From: Daun Johnson
Sent: 18 May 2017 09:09
To: Planning Scanning
Subject: FW: Further Information Required on Your Ref: PP-06035636 Our Ref: M/42/17/HH

Site Plan
Scale - 1:500

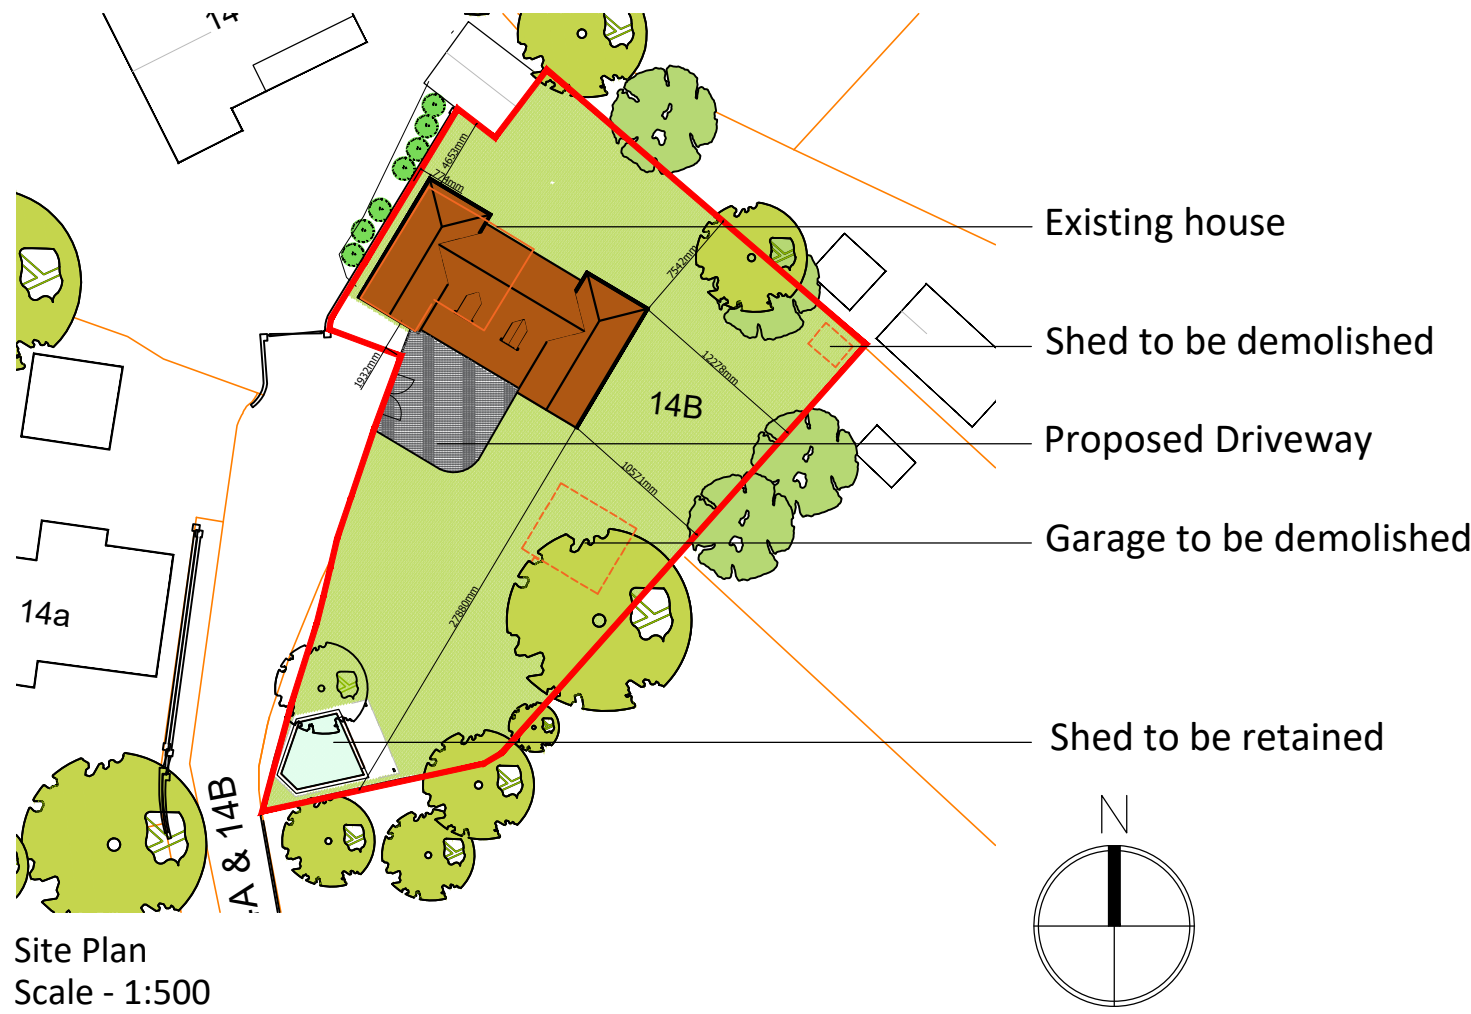
On the proposed block plan please only hatch/highlight the part of the dwelling that the proposed works are being applied.

With regards to the 'proposed' works the floor plans clearly show – in blue shading – the proposed works. The existing dwelling is shaded grey.

Proposed Location Plan
Scale - 1:1250

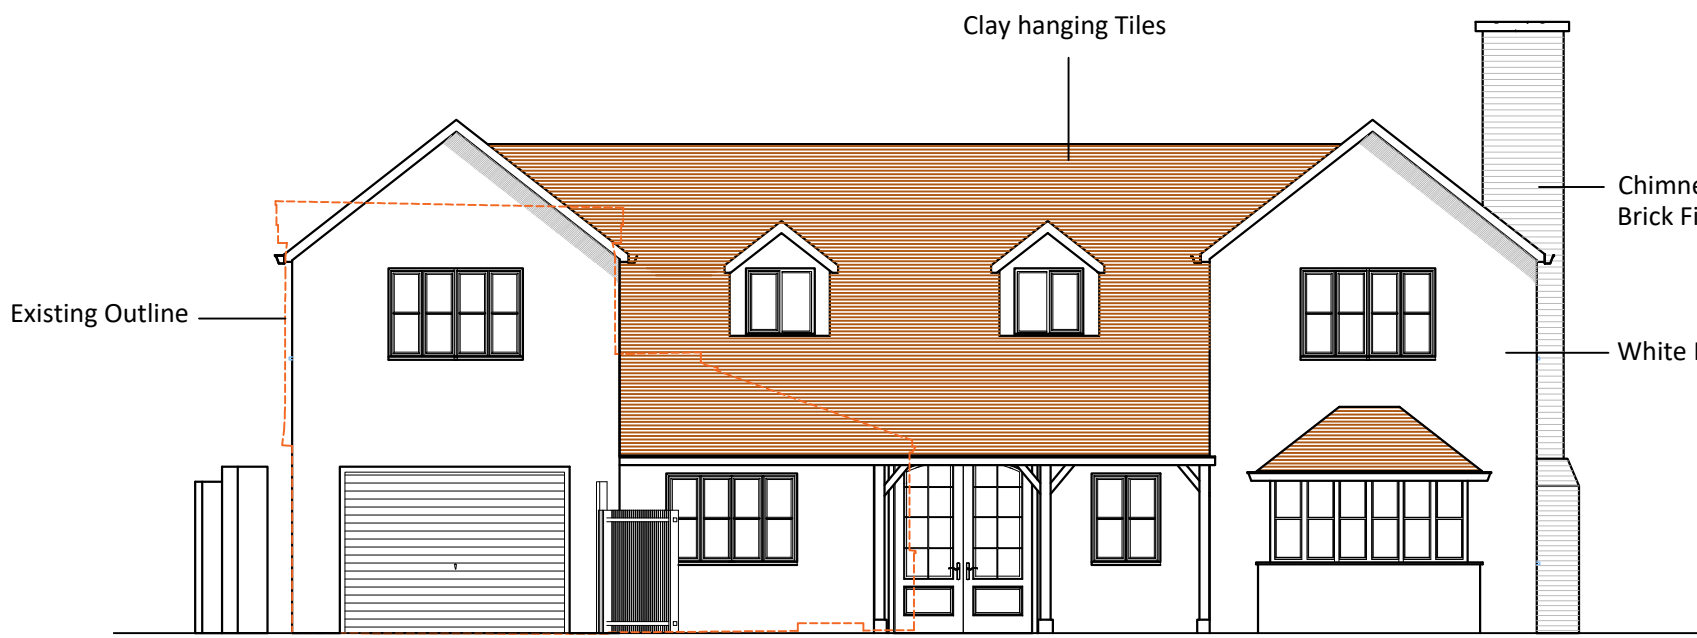
On the proposed location plan, please provide one named road. Unfortunately 'private road' is not a named road.

With regards to the named road issue, the existing dwelling is located on a private drive off of Seaway. Seaway is clearly shown and annotated on the location plans – both proposed and existing.
